Re: Matthews Landing Amenity Center and Pool

This department has reviewed the plans you submitted for the Matthews Ridge swimming pool to be constructed in Lillington, NC. This plan review was conducted in accordance with the current North Carolina Rules Governing Public Swimming Pools (15A NCAC 18A .2500).

The plans are approved reliant upon the following comments:

1 Enlarged Restrooms

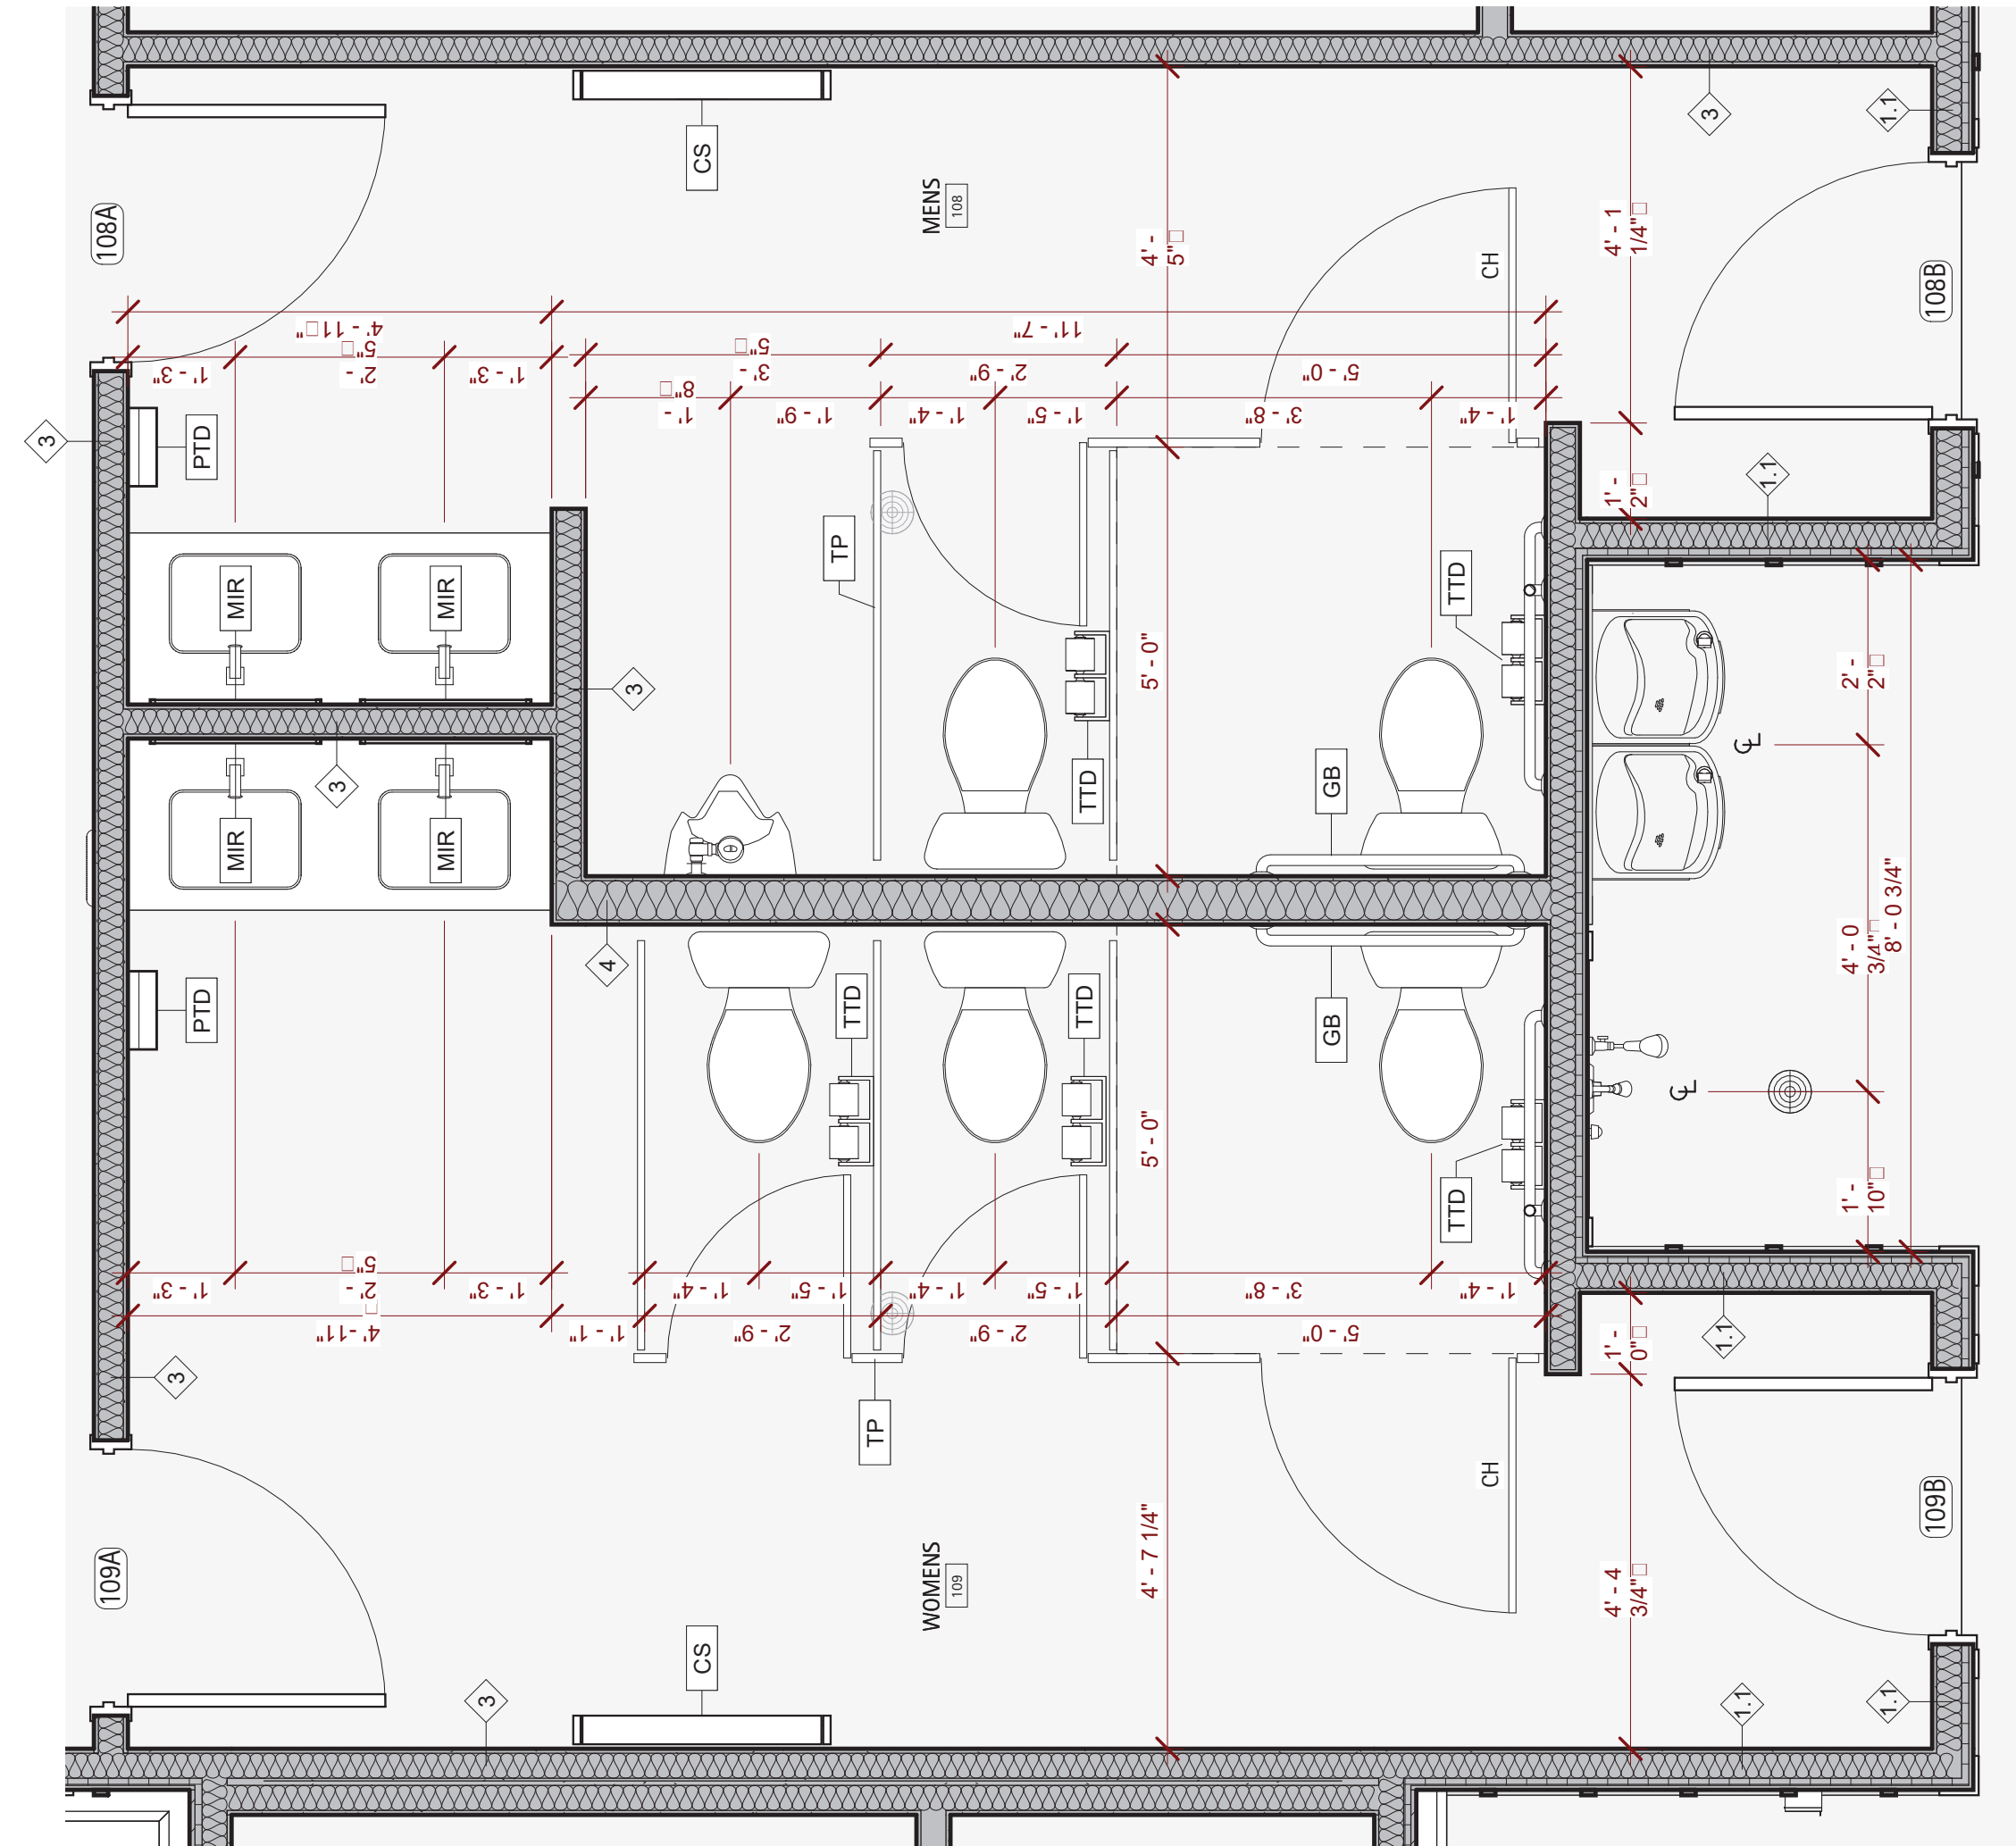
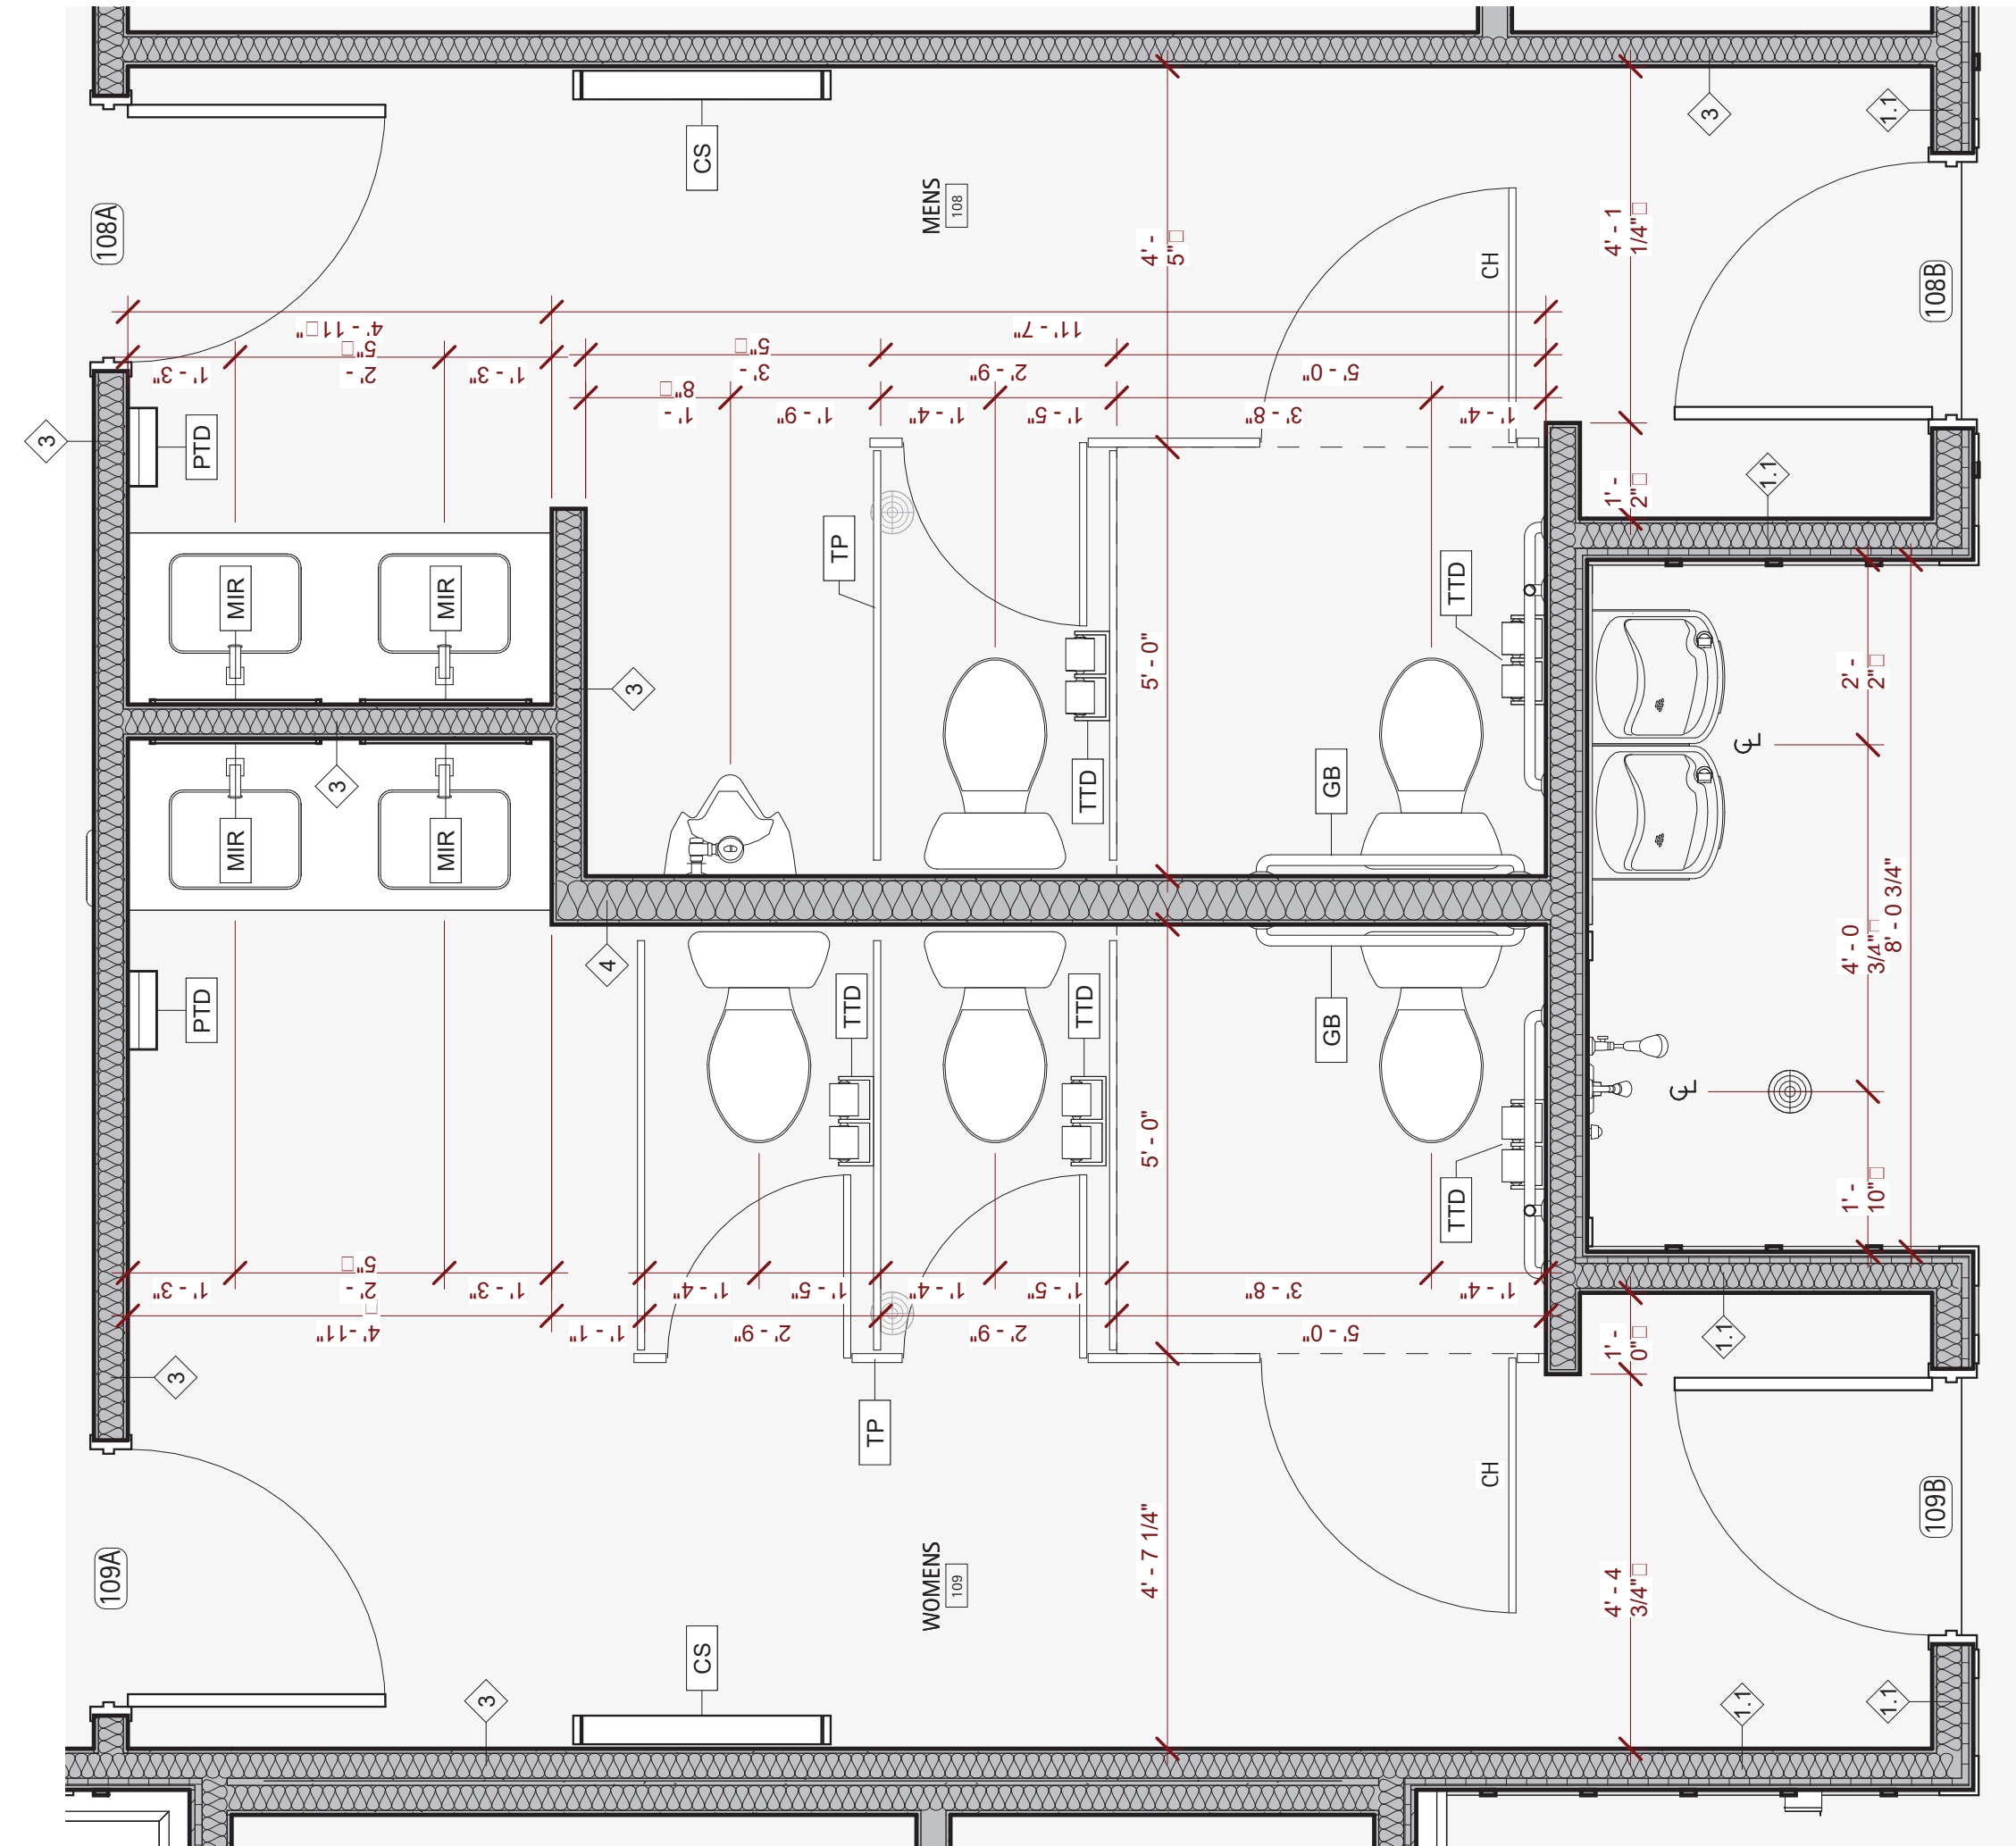
- Soap dispensers are required and shall be provided at each lavatory per 15A NCAC 18A .2526 (j). No soap dispensers are shown on page A4.0 Enlarged Plans and Details.

- The fixtures required for a bather load of 212 (106 male and 106 female) as figured by surface area of 3182 sqft divided by 15 sqft per person for areas <5ft or less in depth are 2 toilets, 2 lavatories and 2 urinals for males and 3 toilets and 3 lavatories for females. The current pool restroom plans show 1 less urinal in the male restroom and 1 less lavatory in the female restroom than required. There is a family restroom within the clubhouse great room that could meet the additional requirements provided this restroom is continually available to pool visitors. If the great room is to be secured and bather access denied at any time, the required fixtures shall be provided in the accessible restrooms.
